CITY OF PORTLAND

July 28, 1999

RE: 145 Braintree St
CBL: 333-H-009

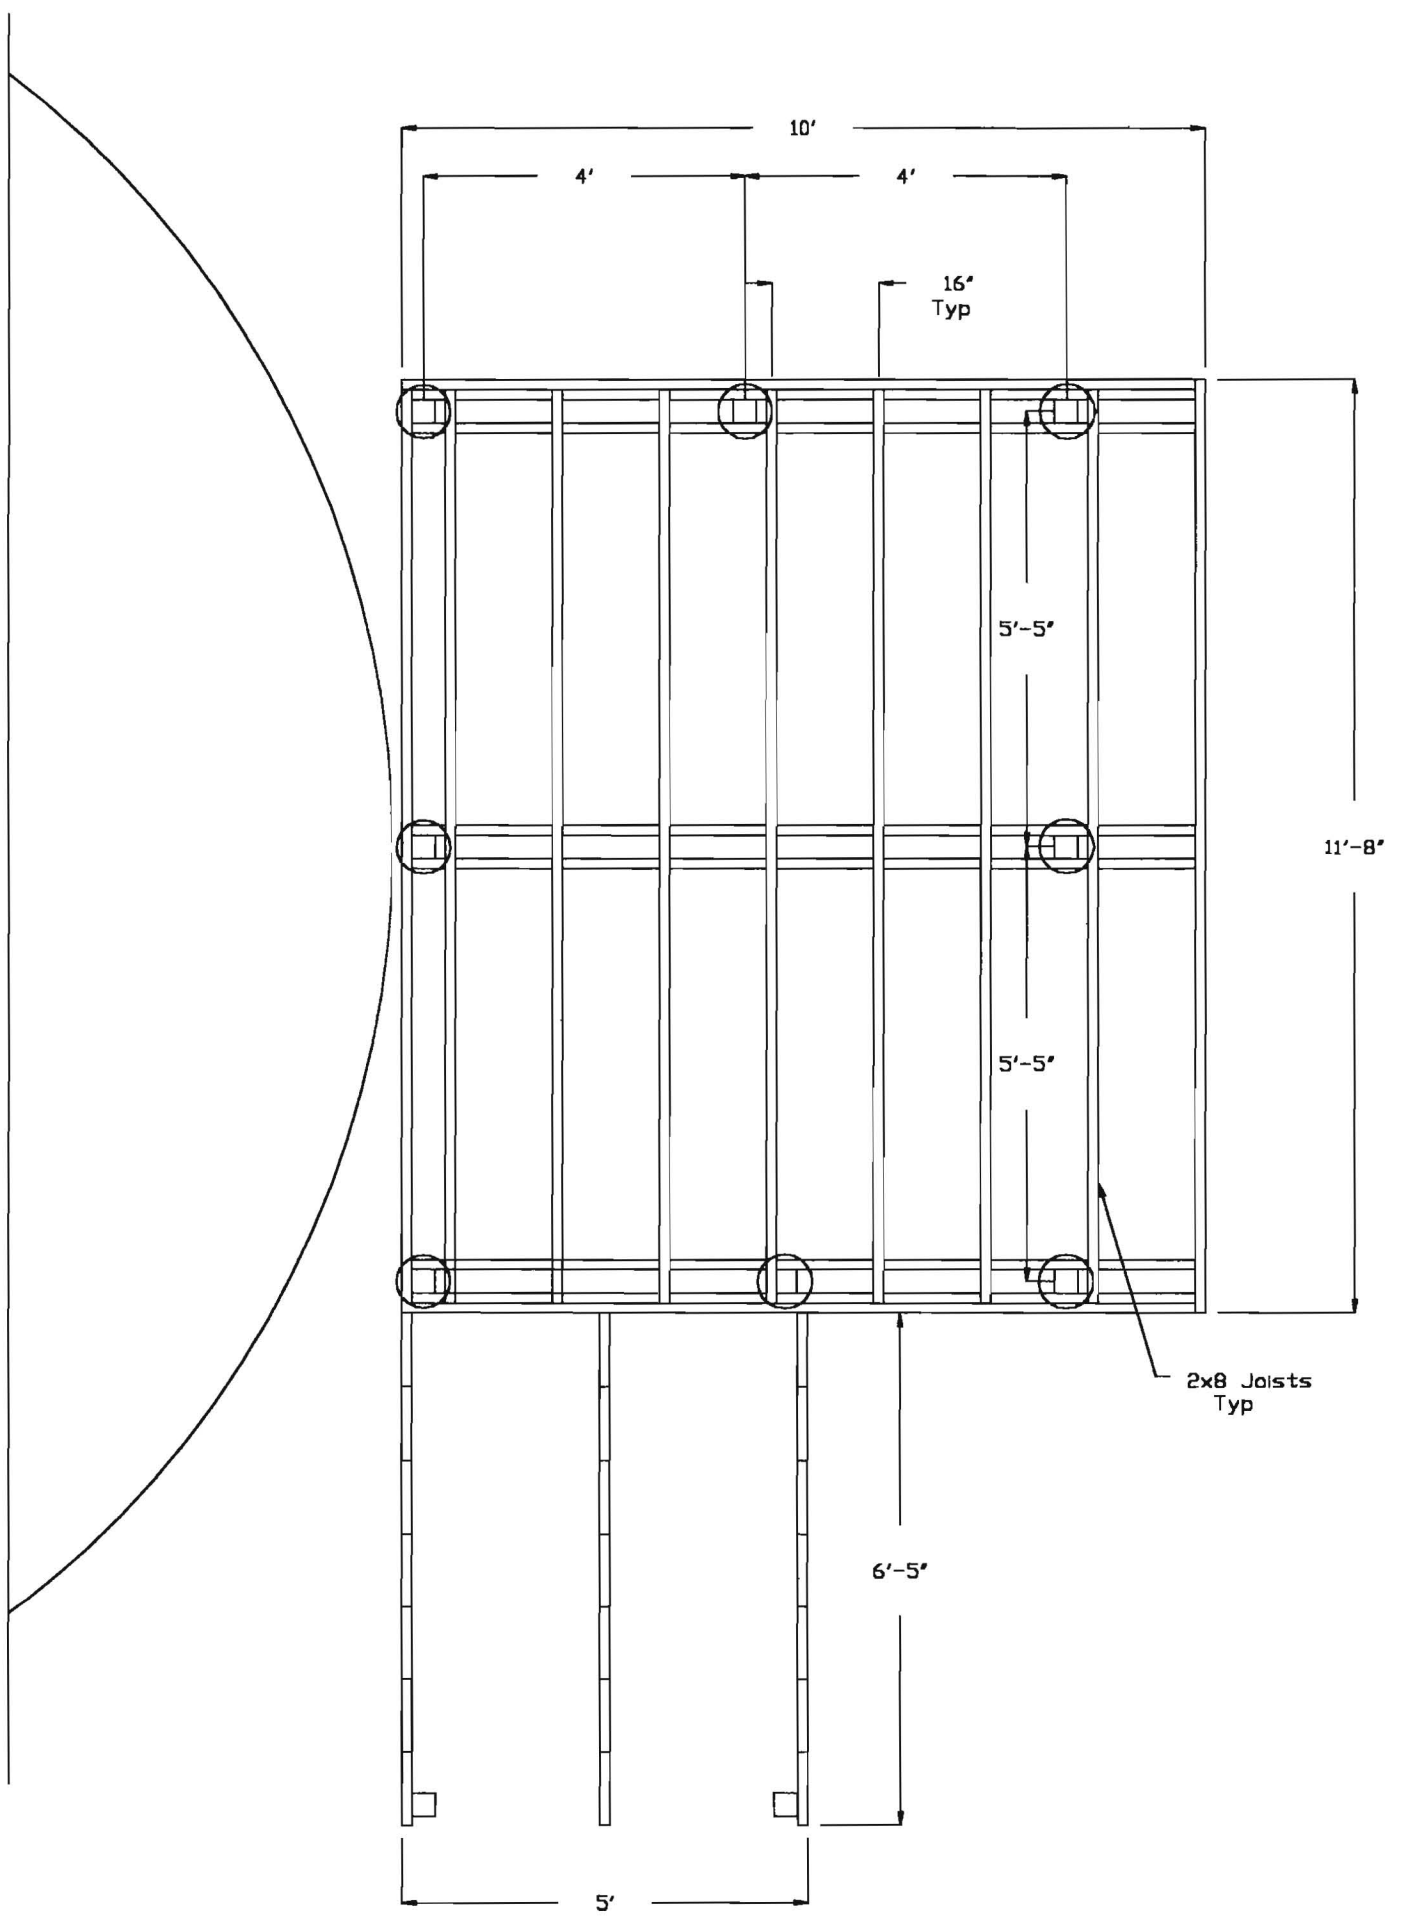
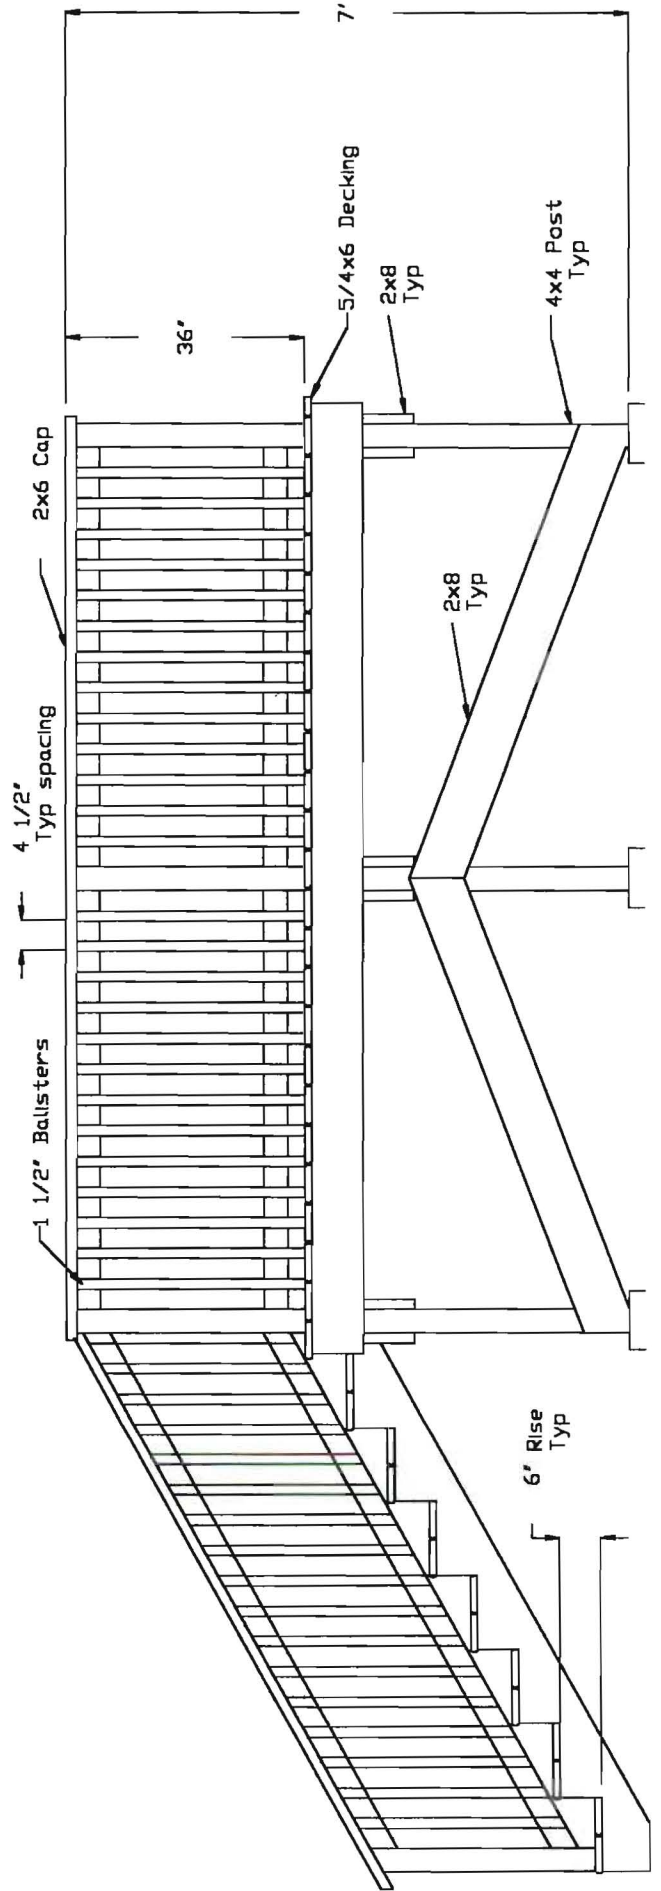
It was recently noted that your swimming pool was not installed in accordance with Section 421.0 of the 1996 BOCA Code as stipulated in your permit issued July 14, 1998.

The deck around the pool does not adequately protect the pool as is required. Further there appears to be no permit for this deck in our files. You must apply immediately for a permit for the deck.
